City of Portland, Maine - Building or Use Permit Application

Proposed Project Description:
Amendment to permit # 020404. Two 8' x 16' decks were not shown on original permit.

**SPECS FOR DECKS ON BUILDING K
WASHINGTON CROSSING- DELAWARE COURT**

Re: Deck app. Building "K" Delaware Ct.

**DETAILS AND SPECIFICATIONS  
 DUPLEX HOME  
 WASHINGTON CROSSING**

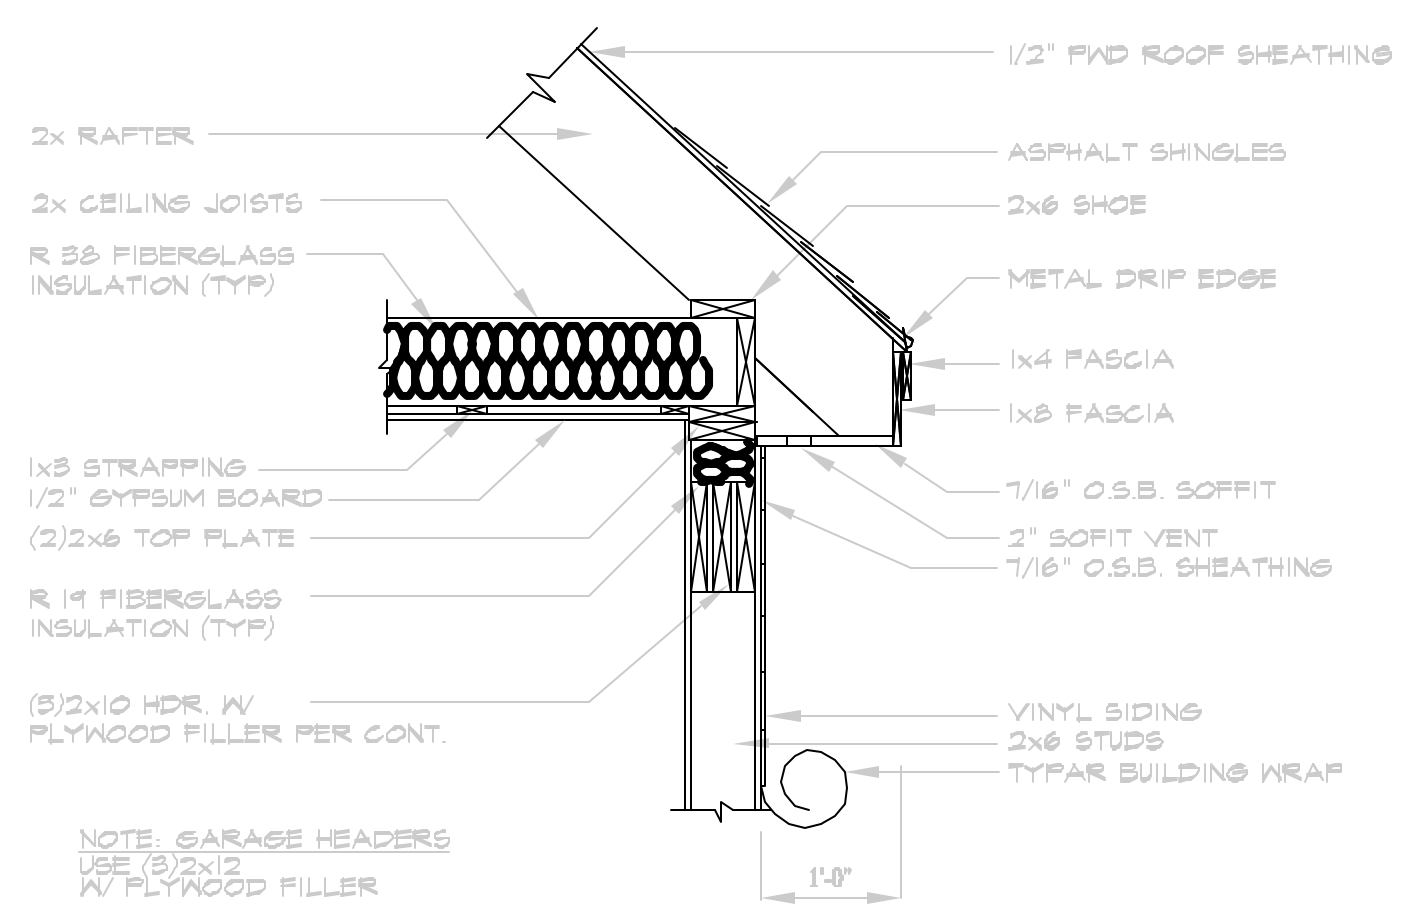
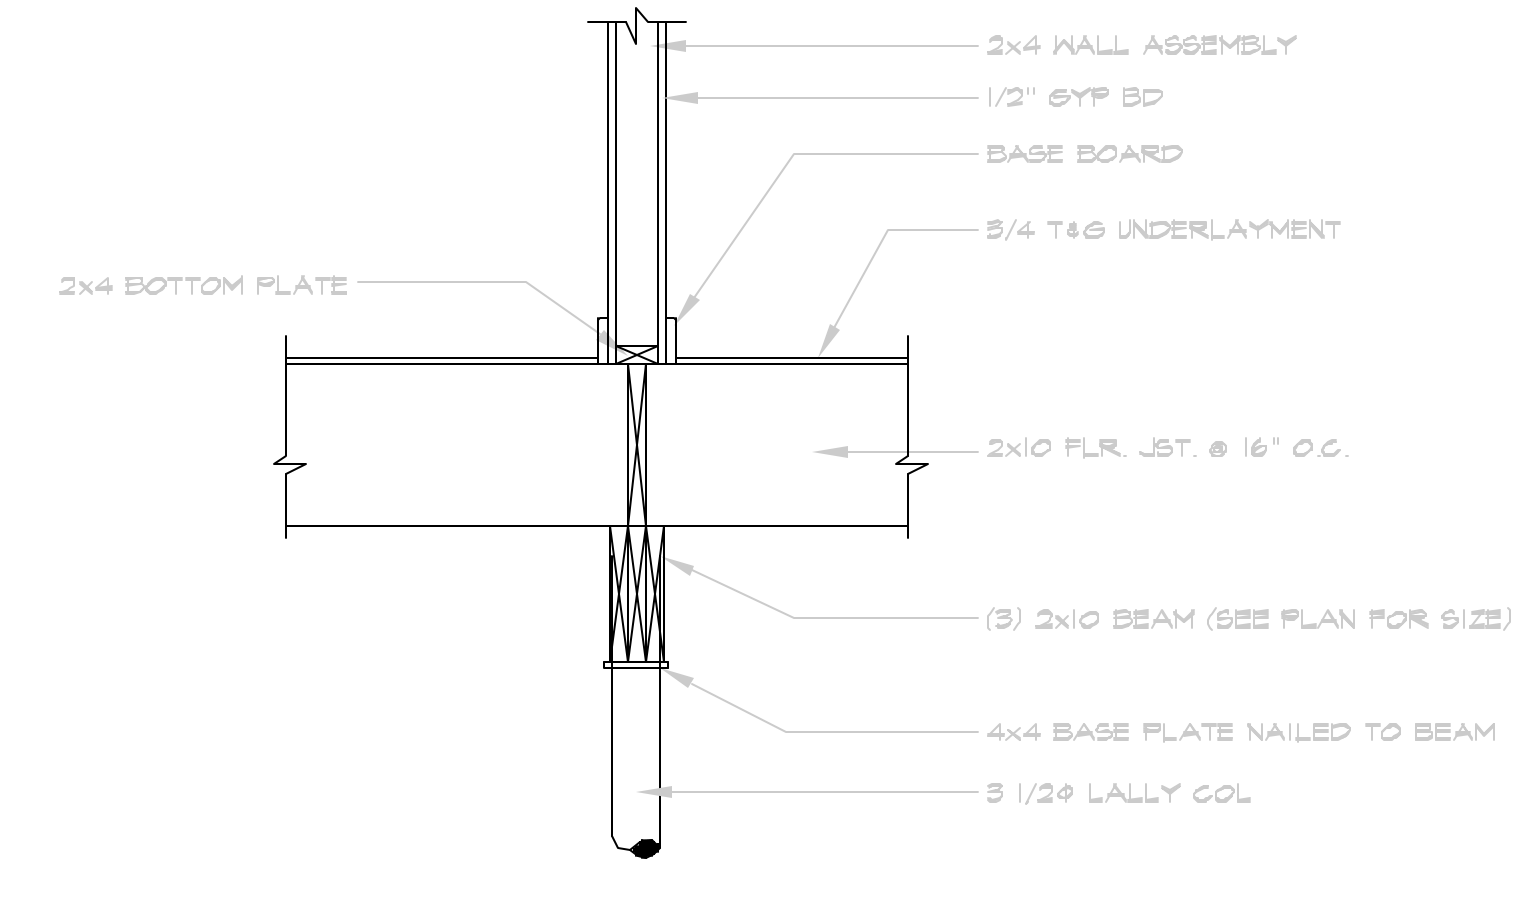
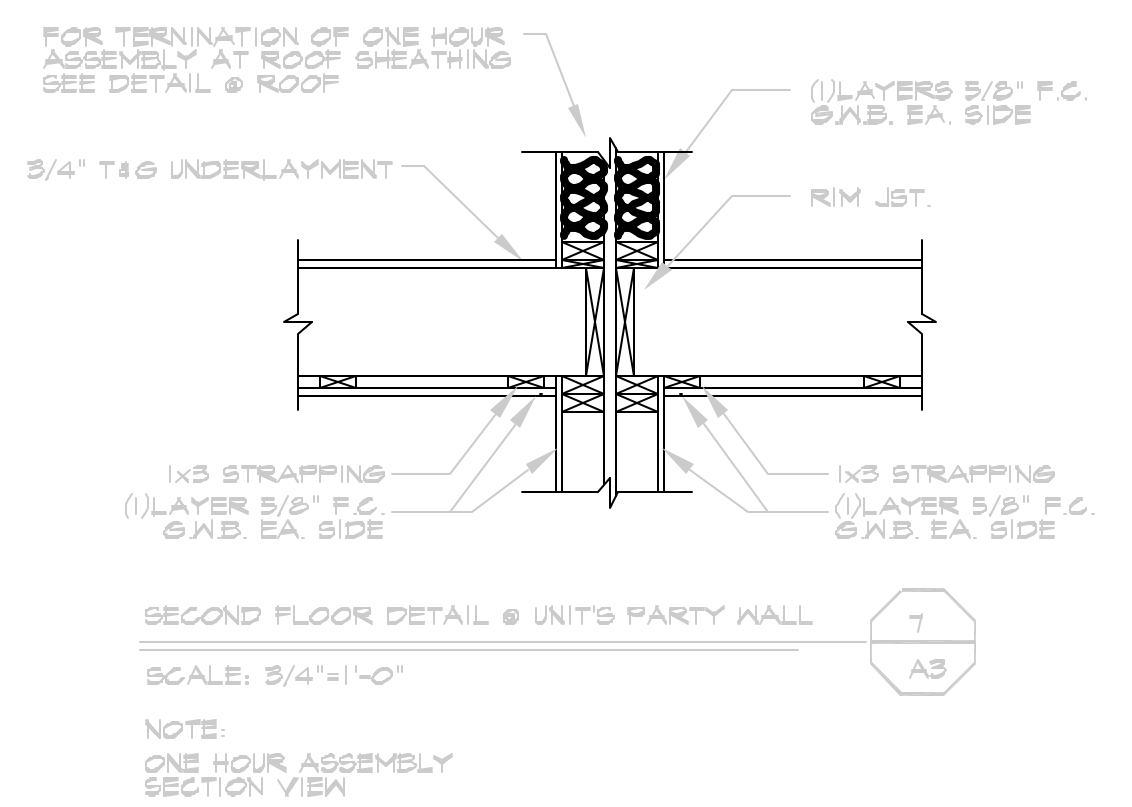
Dept: Zoning	Status: Approved	Reviewer: Marge Schmuckal	Approval Date: 11/21/2002
Note:			Ok to Issue: <input checked="" type="checkbox"/>
Dept: Building	Status: Approved with Conditions	Reviewer: Mike Nugent	Approval Date: 12/17/2002
Note:			Ok to Issue: <input checked="" type="checkbox"/>
1) 1) A minimum 8" sonor tube must be placed 48 inches below grade. 2) 3- 2"X 12" Carrier to be used with a 6 foot spacing of upright support on item #1. 3) Builder advises that Guards will be 42 inches in height with openings less than 4 inches, no LADDER effect.			
Comments: 11/25/2002-mjn: Need Deck Detail, Applicant notified Sent some details, need more

What will the outer beam be?

Footings?

Spacing of supports?

Spacing of Balusters?

8'x16'
Floor Joists to be 2'x8' pressure treated
Posts to be 4"x4" Red Cedar
Railings to be 36" in height Red Cedar
Decking to be Red Cedar
